OUTLINE

Reference: H03-0628-18 **Date of Decision:** 20th September 2018
Applicant: W David Branton (Farmer) & The Honourable R F J Carington
Willow Tree Farm
Deeping St Nicholas
Spalding
Lincs
PE11 3BN
Location: Littleworth Drove Deeping St Nicholas Spalding
Description: Residential development - re-submission of H03-0366-17

The determined plans are: Drw No 3113-17 02 (Incorporating layout), Planning Design & Access Statement - Amendment 1 (Ref: 3113-17 Rev A)

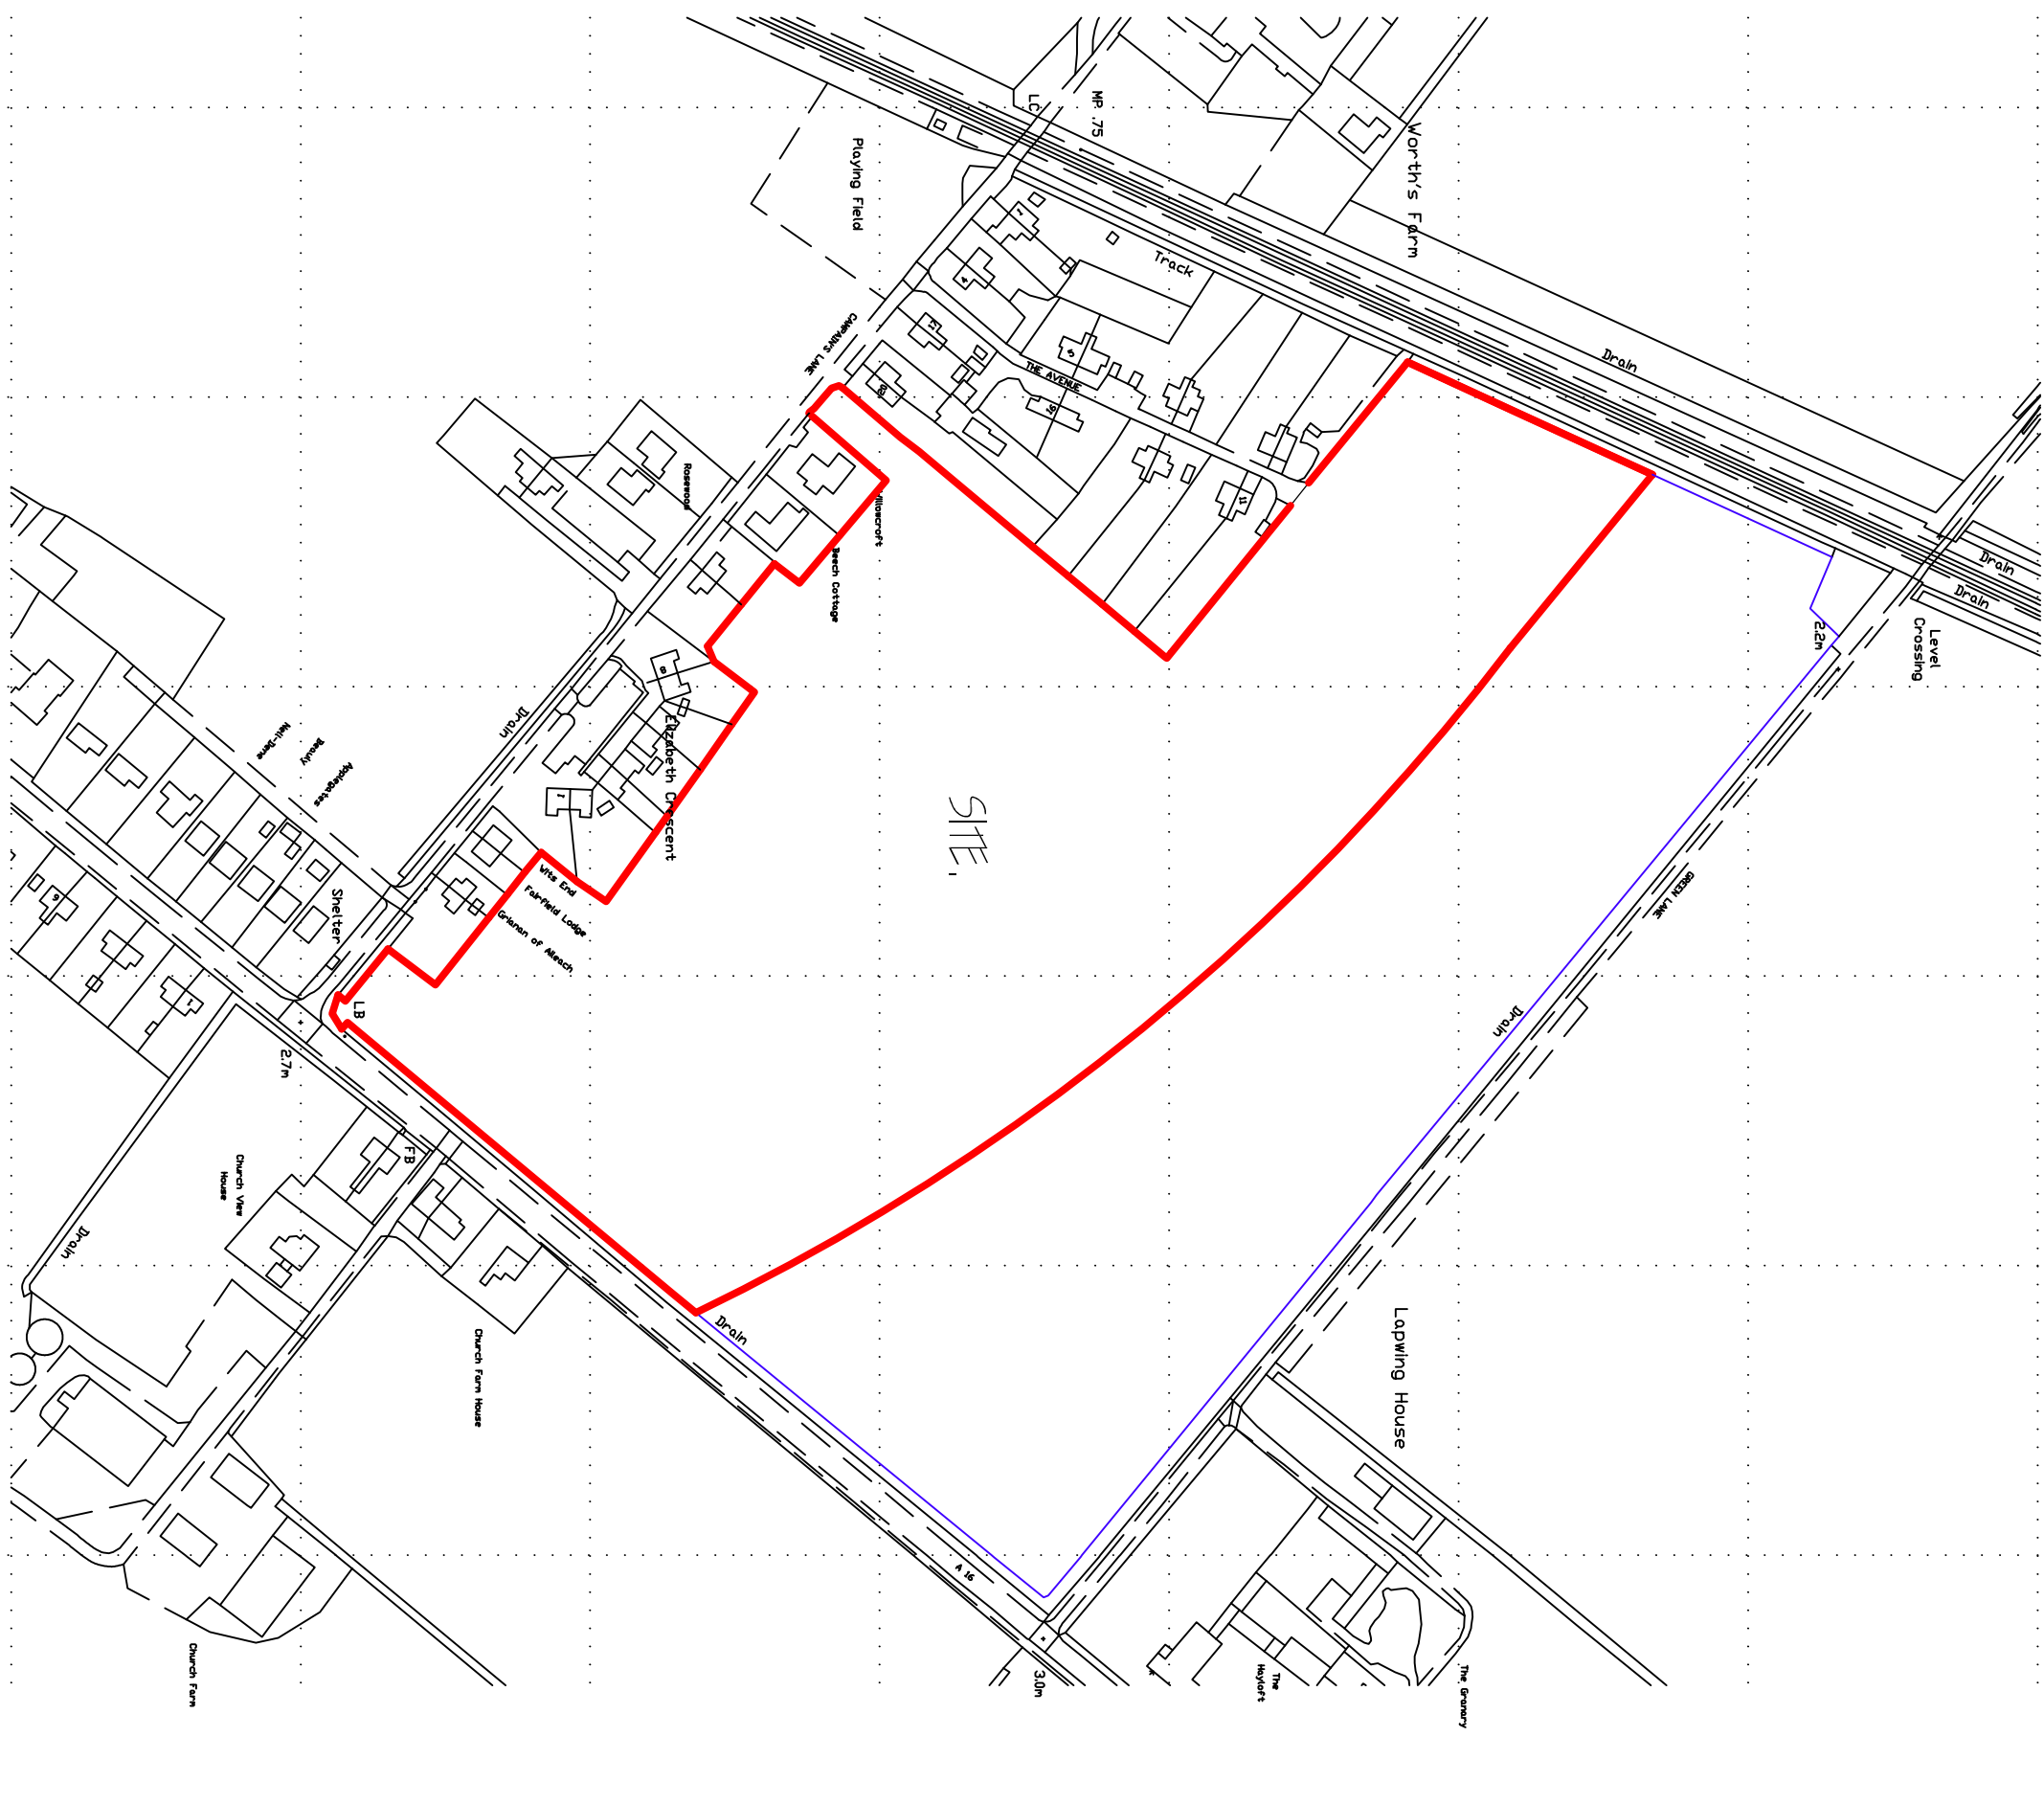
- 1 The size, scale and siting of the development, at the end of a settlement which is characterised by its linear form, would be unacceptably harmful in visual terms and would present an out of character and overwhelming urbanisation of open fields which currently give this end of Deeping St Nicholas a pleasant and green rural setting.

- 2 The development is proposed within an area identified as Flood Zone 3 (high probability). The submission has not demonstrated a Sequential Approach to steer development to areas with the lowest probability of flooding or demonstrated. It is the opinion of the Council that there are other reasonably available sites appropriate for the proposed development. Therefore the proposed development does not meet the Sequential Test and is contrary to the provisions of the National Planning Policy Framework 2018 and does not meet the presumption in favour of sustainable development. It has not been

demonstrated that the development provides wider sustainability benefits to the community that would outweigh flood risk, and the development would not therefore meet the National Planning Policy Framework 2018. Furthermore, the proposed development has not provided an adequate Flood Risk Assessment and suitable mitigation measures to demonstrate the safety of the development and safeguard its future occupants. The development is therefore, contrary to the provisions of the National Planning Policy Framework 2018, and does not meet the presumption in favour of sustainable development.
